Re: Observation on the proposed Cloonbaul 110 kV substation and grid connection

ACP Case: VA16.324429 | Applicant: Cunlaghfadda Green Energy Limited

Site Layout Plan
Sheet 2 of 3

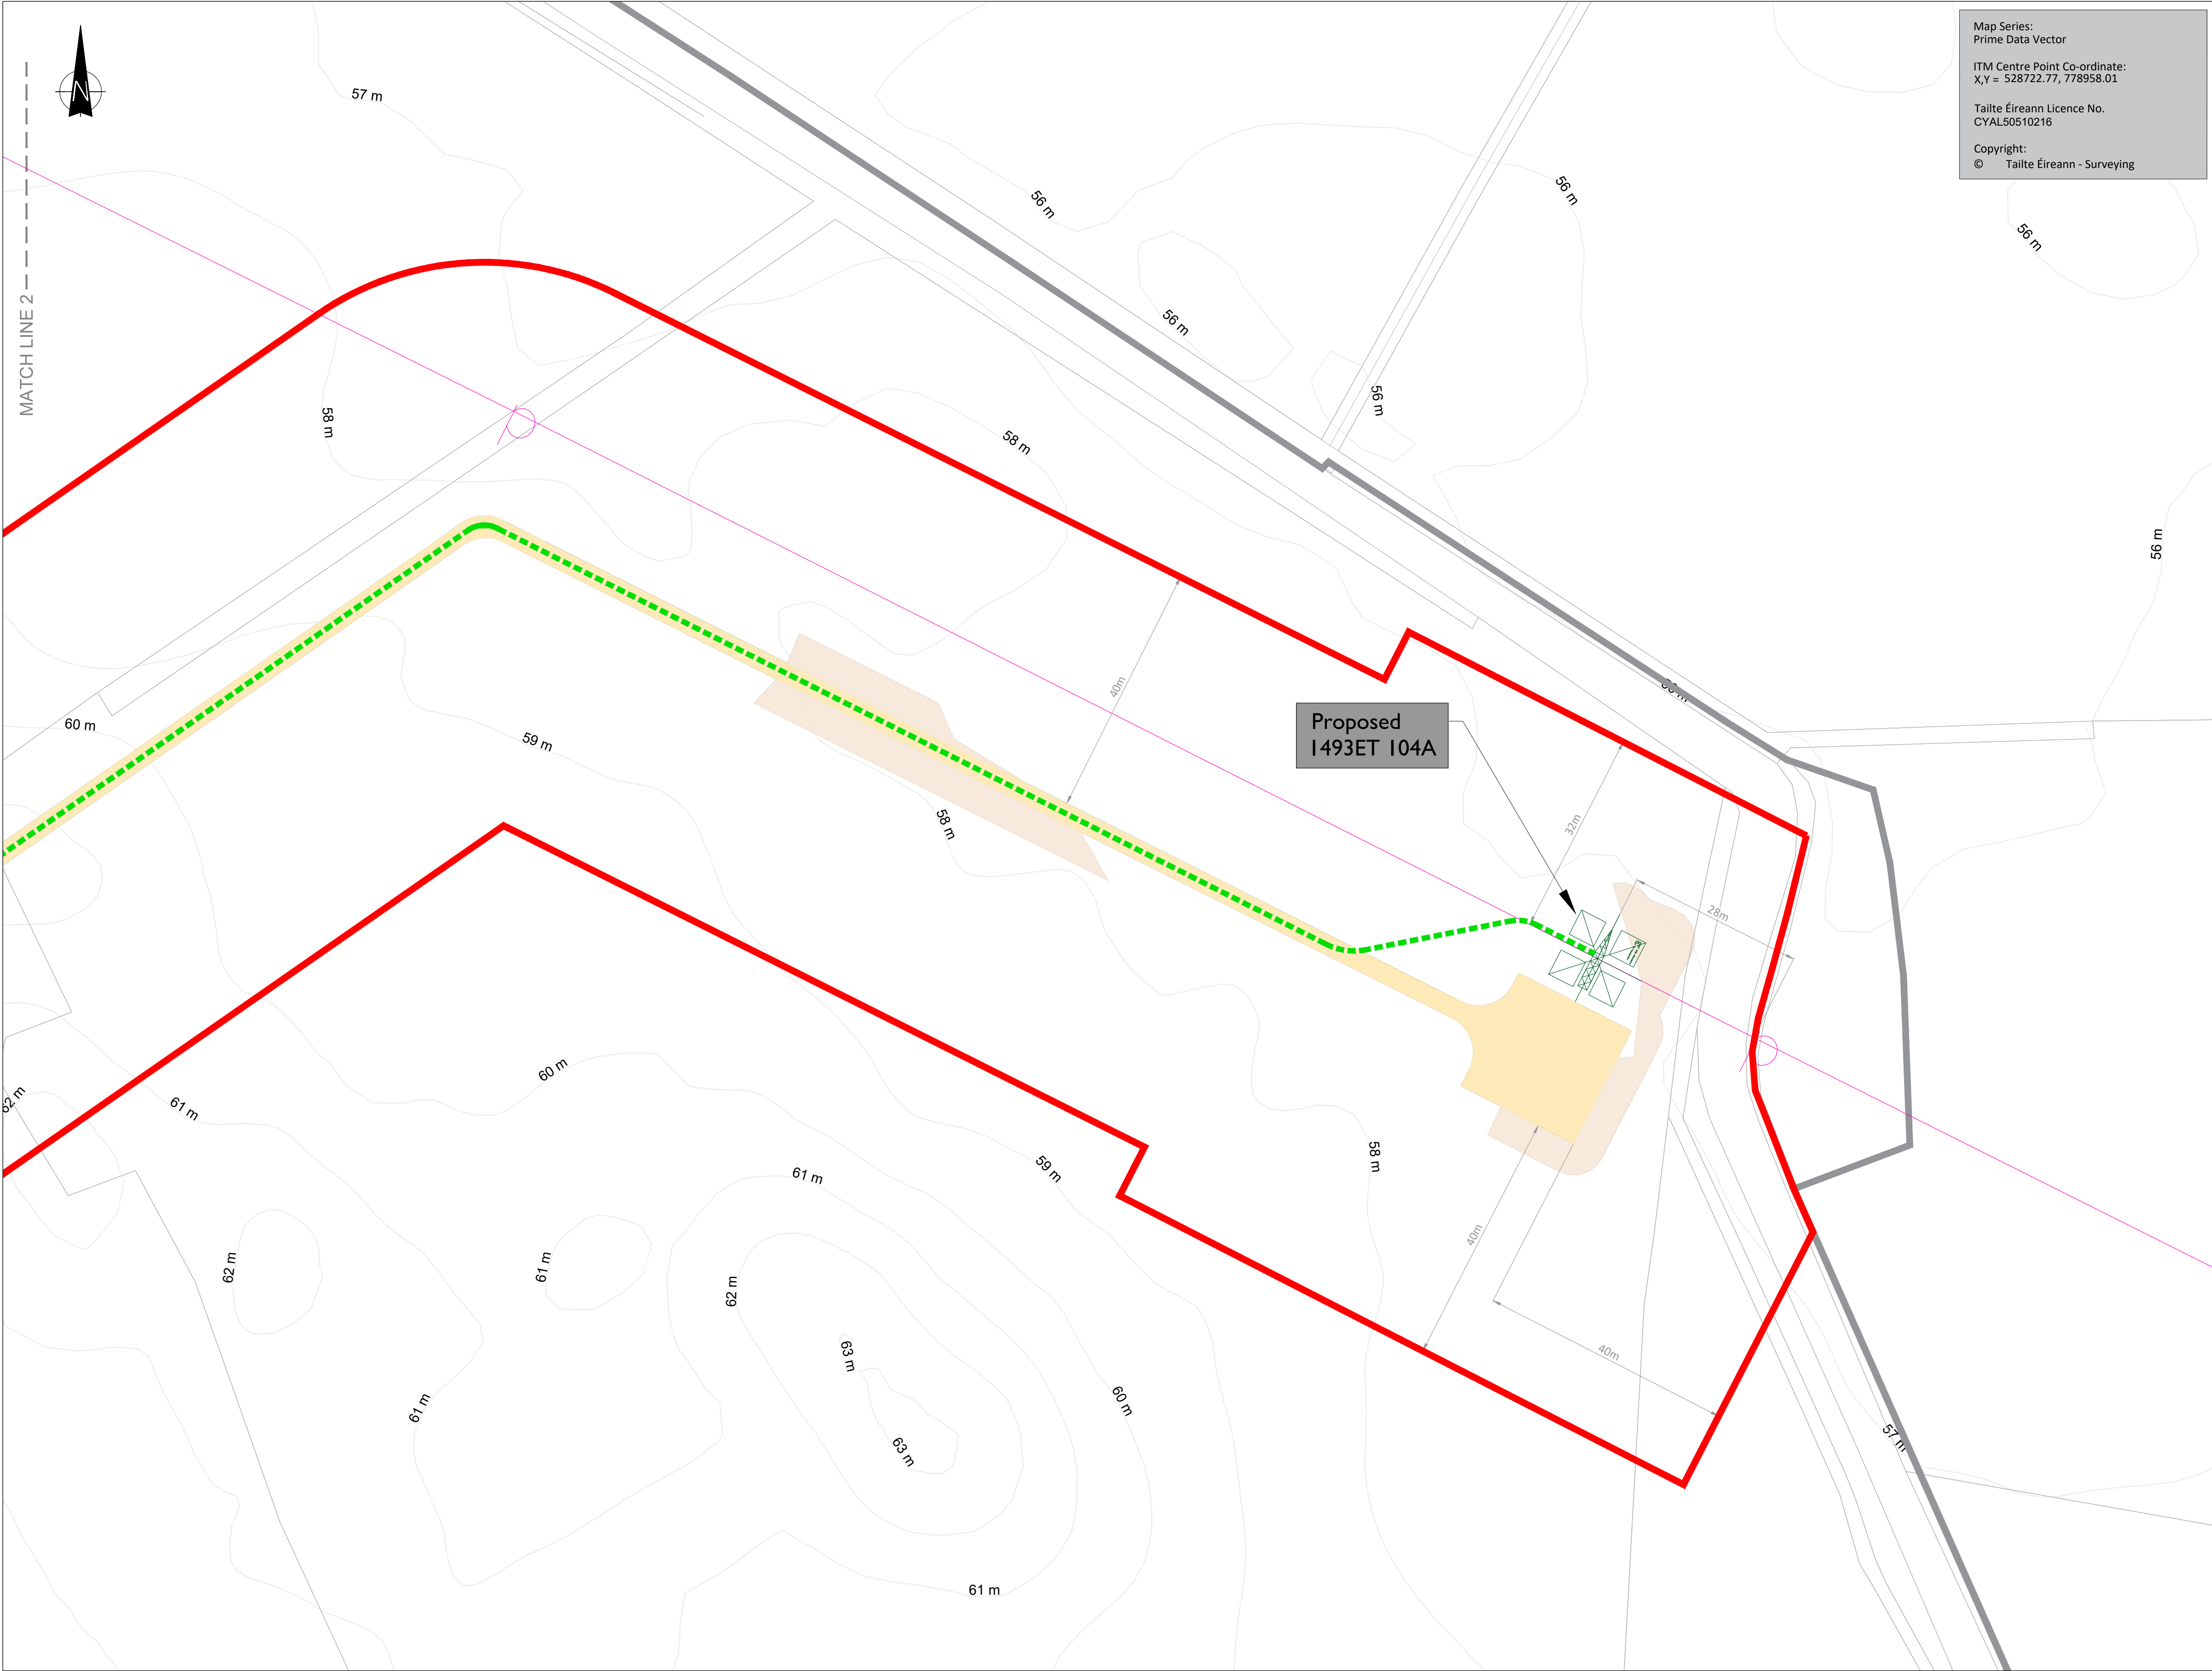
The 1995 Mayo Abbey Archaeological Survey identified an enclosure at or immediately adjoining the proposed substation site and described it as being of immense importance. Its full extent, date, function and relationship with the surrounding archaeological landscape have not been established.

Permanent foundations, hardstanding, drainage, fencing, services and access works could damage both visible and buried evidence. Archaeological uncertainty is a reason for investigation and protection, not permission followed by excavation. The enclosure should be preserved and the application refused.
